Engineers Comments Regarding Surface Water Drainage

Application Reference:	BN/128/24/RES	Reviewer Reference:	ADC/SB
Planning Officer:	Simon Davis	Date of Review:	11/11/2024
Site Name:	Eastmere Stables Eastergate Lane Eastergate PO20 3SJ		
Application Description:	Approval of reserved matters (other than access) following the grant of BN/99/22/OUT (APP/C3810W/22/3312864) for 9 No. dwellings. This application is in CIL zone 3 and is CIL liable as new dwellings.		
Assessment Number:	1 of 1

Percolation Trial Pit TP#3

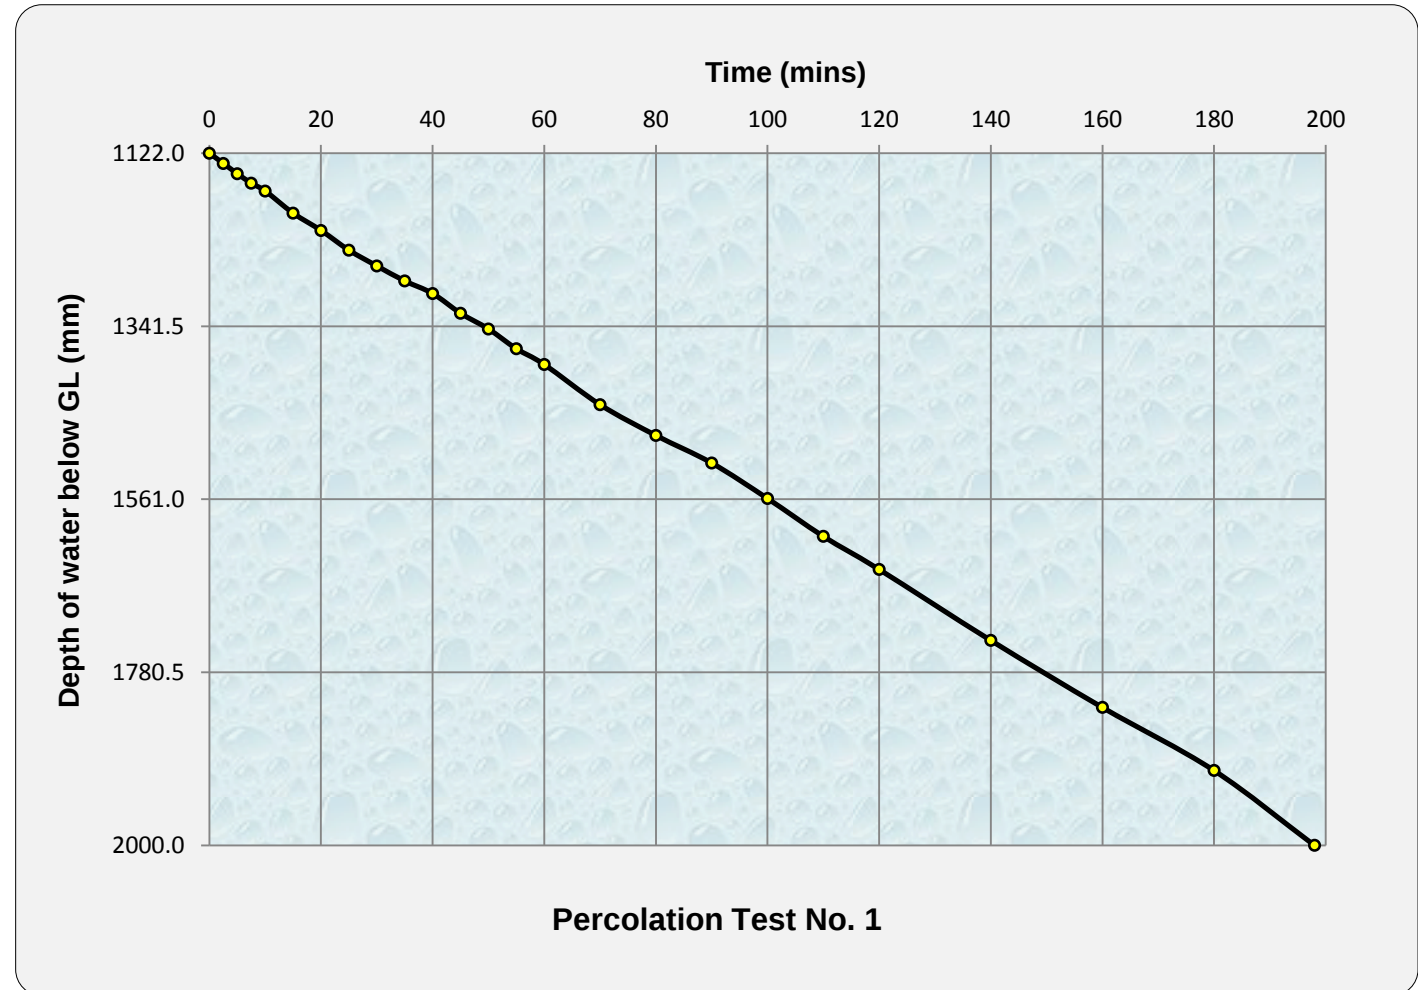
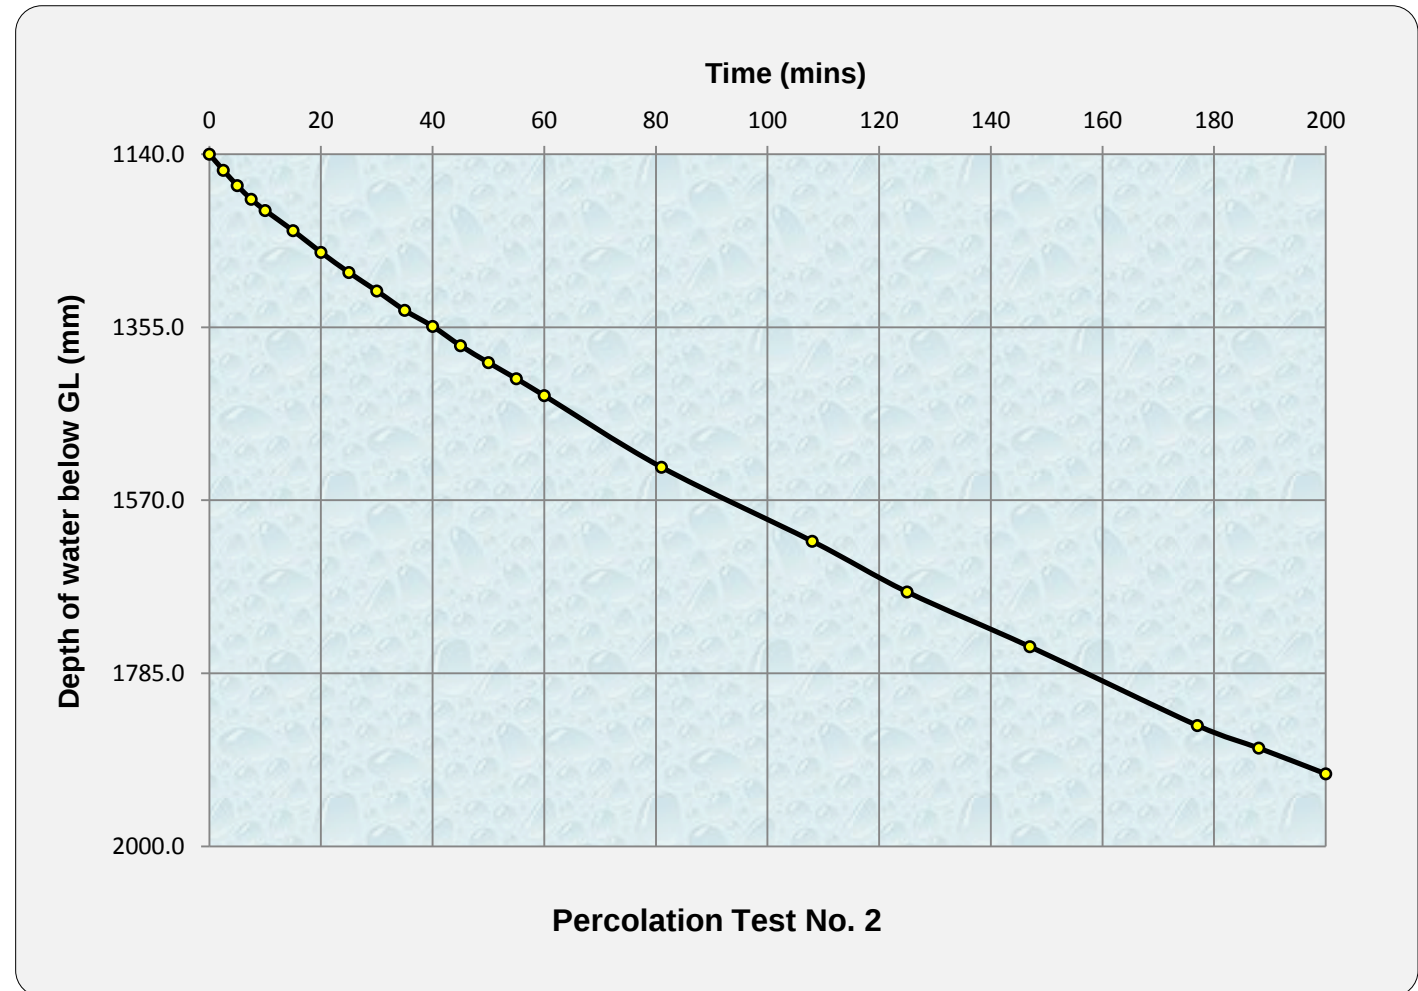
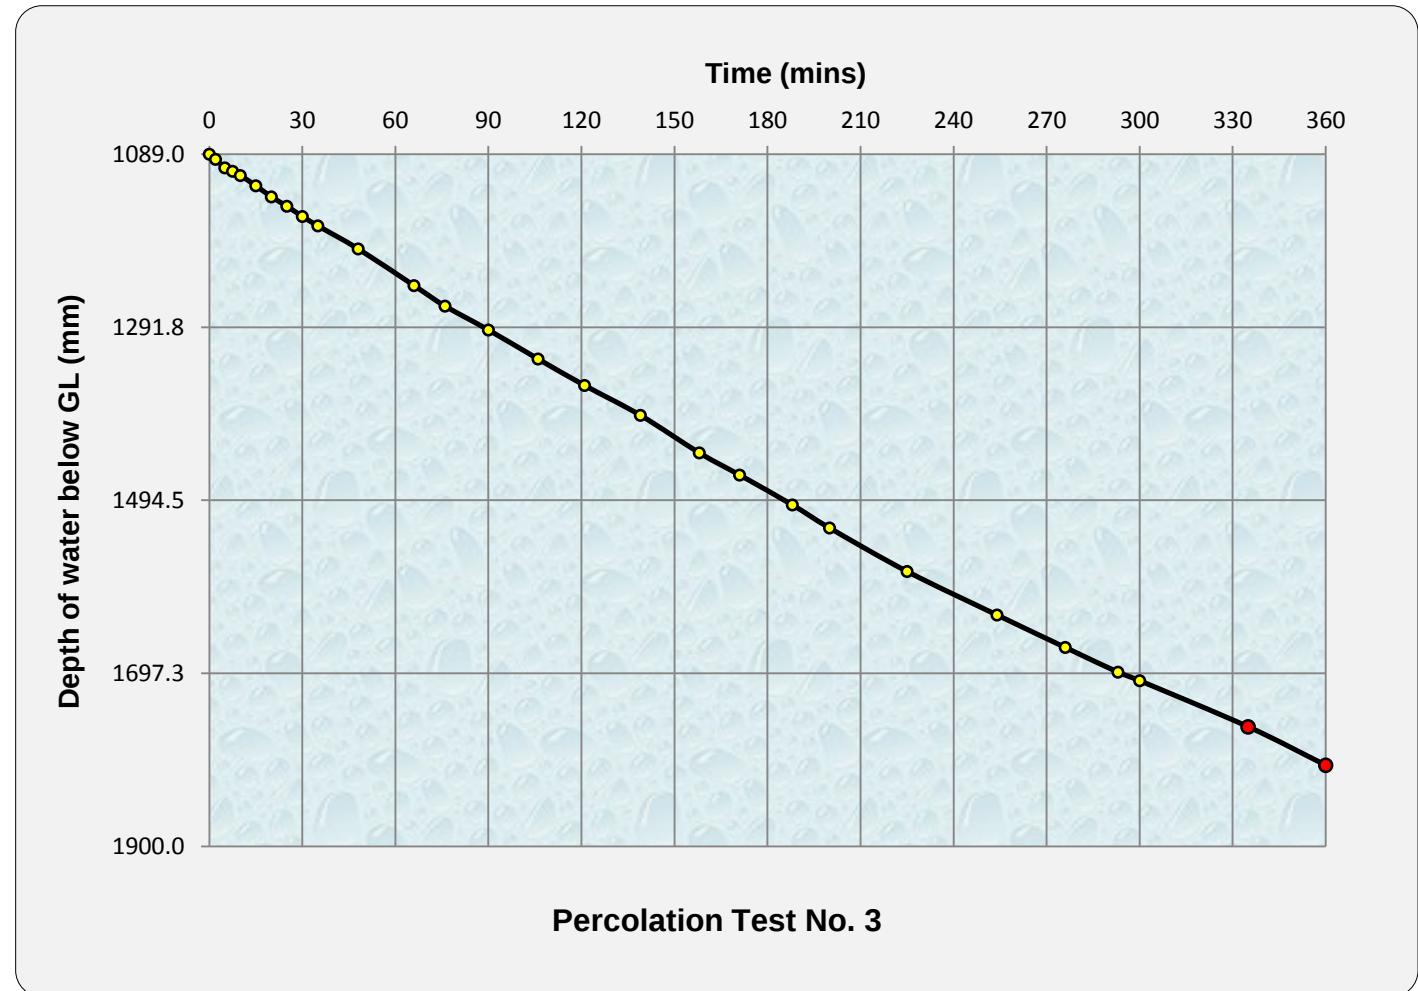
The comments regarding potential surface water ingress to the borehole GWP#3 are not consistent with the infiltration rates evidenced at TP3 – the closest trial pit. The slowest infiltration rate at this point is 1.28×10^{-5} m/s in a pit that was 2m deep. The results indicate that the water level dropped by approximately 2mm/minute in a previously saturated trial pit (if the rate was linear). Therefore, if

surface water had entered the monitoring point you would expect the water levels to drop following ingress if groundwater was not present.

Percolation Trial Pit TP#4

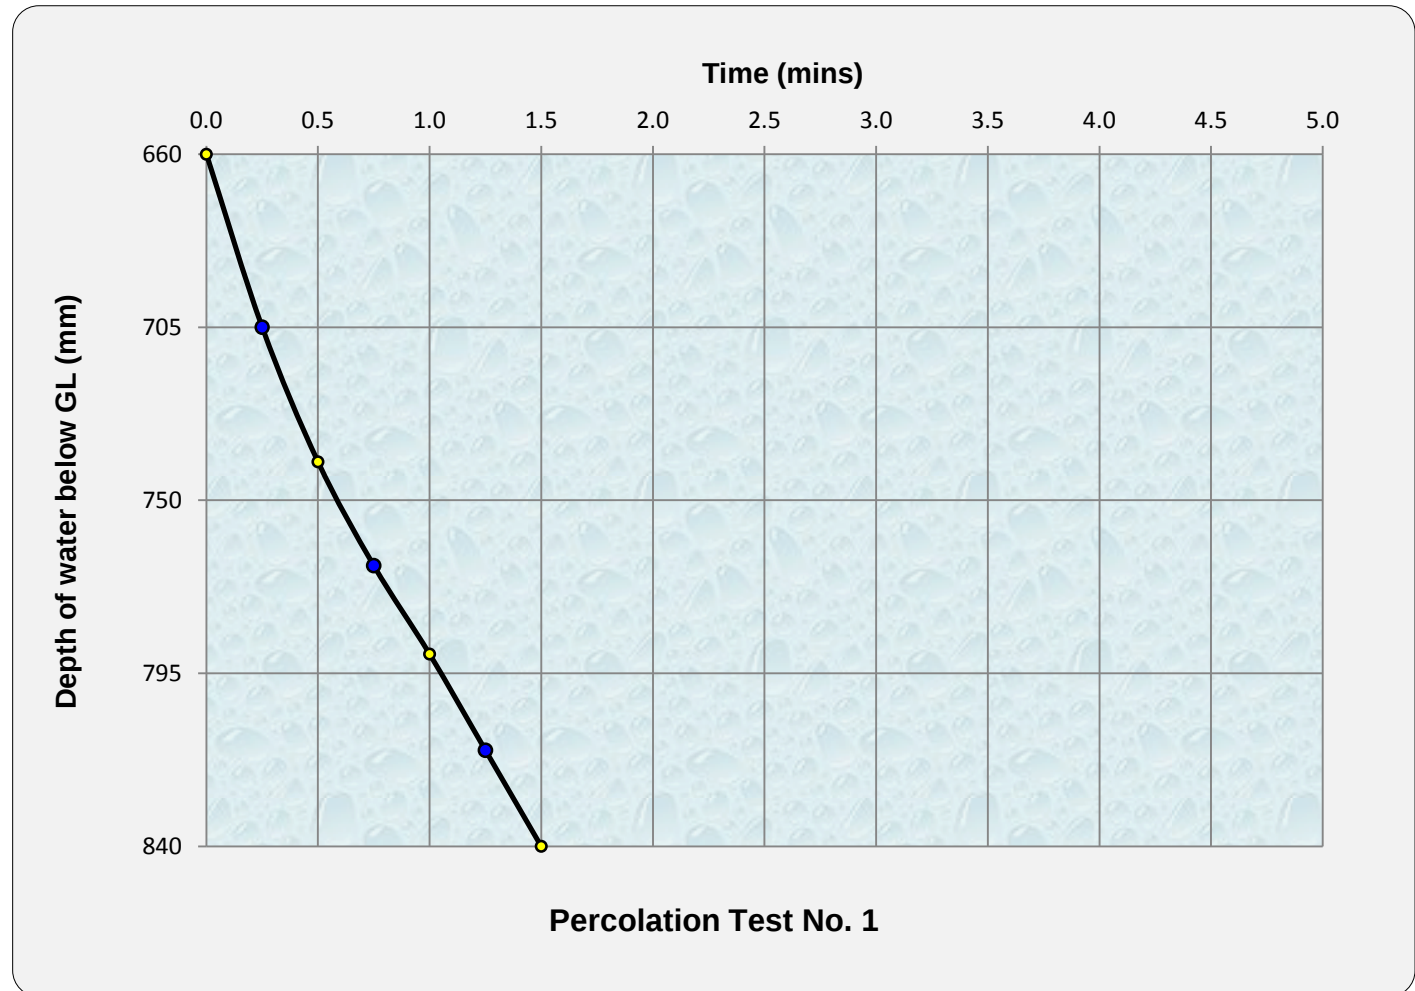
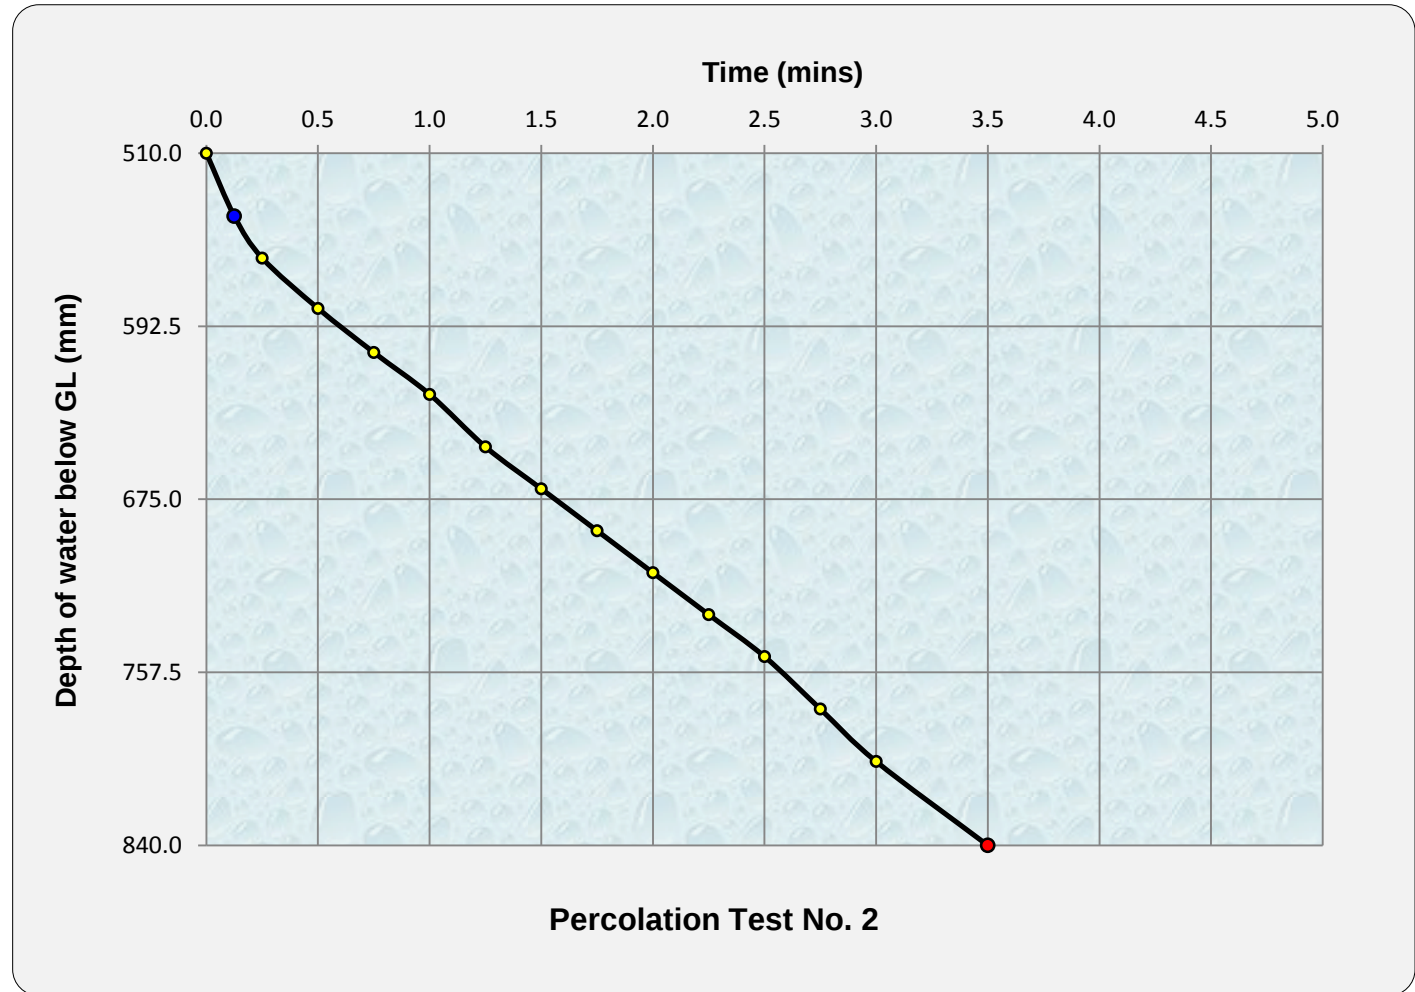
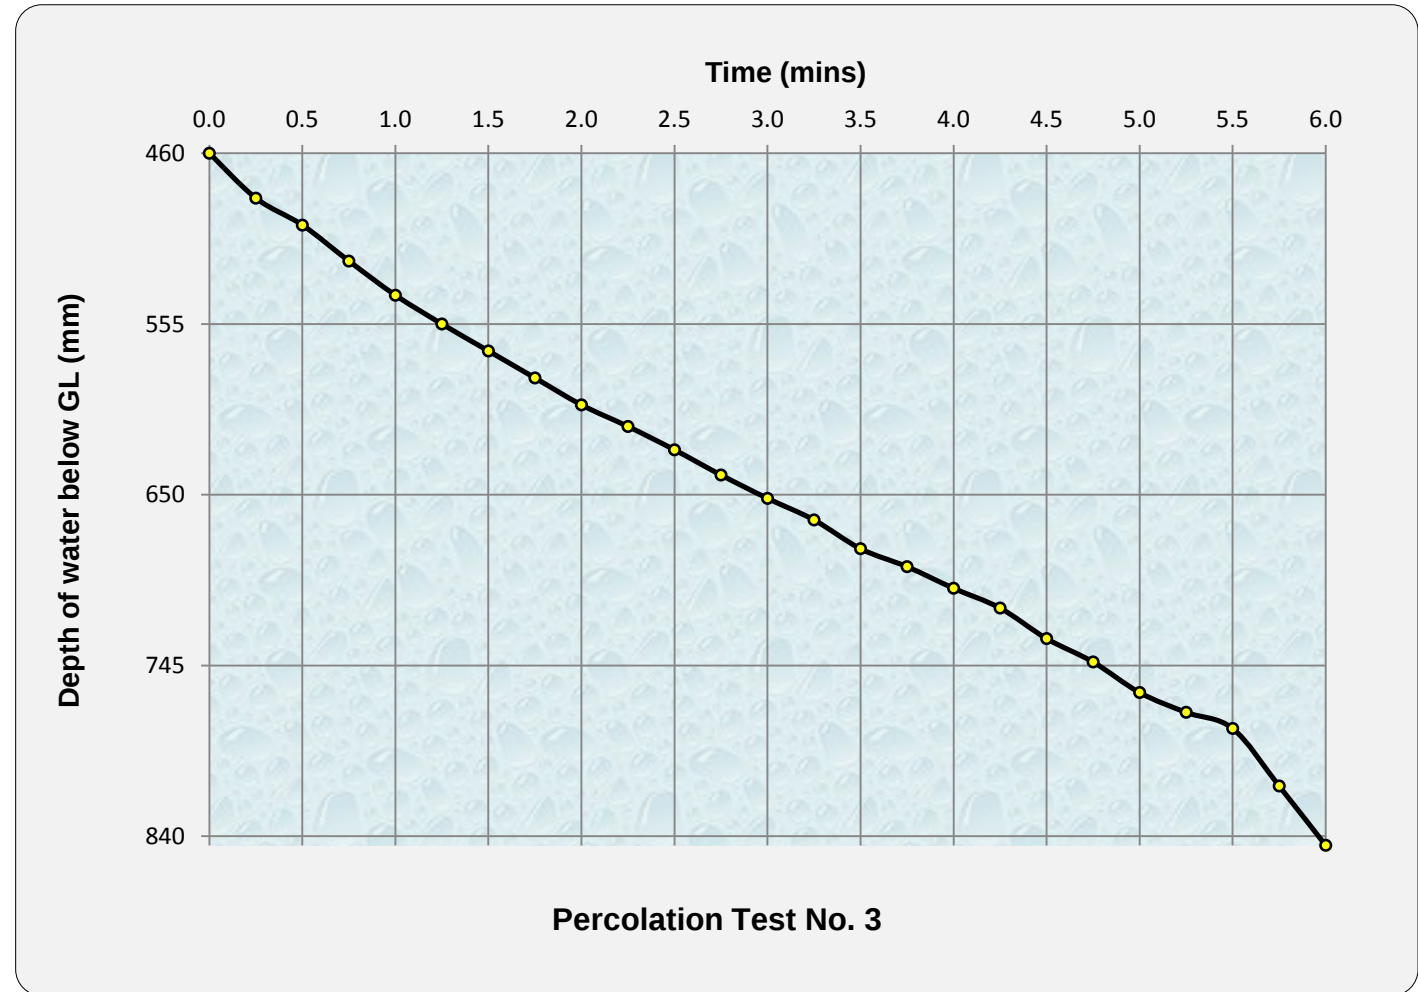
Further information is required regarding the ground investigations that have been completed on the site. Four sets of infiltration tests have been completed, however 3 of these were too deep. Only one trial pit, TP4 was set at a depth which allows for 1m of unsaturated ground (freeboard) between the base of the infiltration feature and the peak groundwater levels. The slowest infiltration rate evidenced in this pit was 3.069×10^{-5} m/s or 0.1105m/h.

The head of water in the tests in TP4 is not consistent, 180mm in test 1, 330mm in test 2, 385mm in test 3, the design is based on the formation of the permeable paving being 700mm below ground level with a maximum head of 600mm.

The design will need to be altered to account for the recorded groundwater levels. Further winter infiltration testing at the proposed location, depth and head of water for the infiltration design will be required.

- Winter groundwater monitoring data from 2021-2022 that is referred to in the accompanying email.
 - Further winter infiltration testing at the proposed location depth and head of water to correspond with the design.
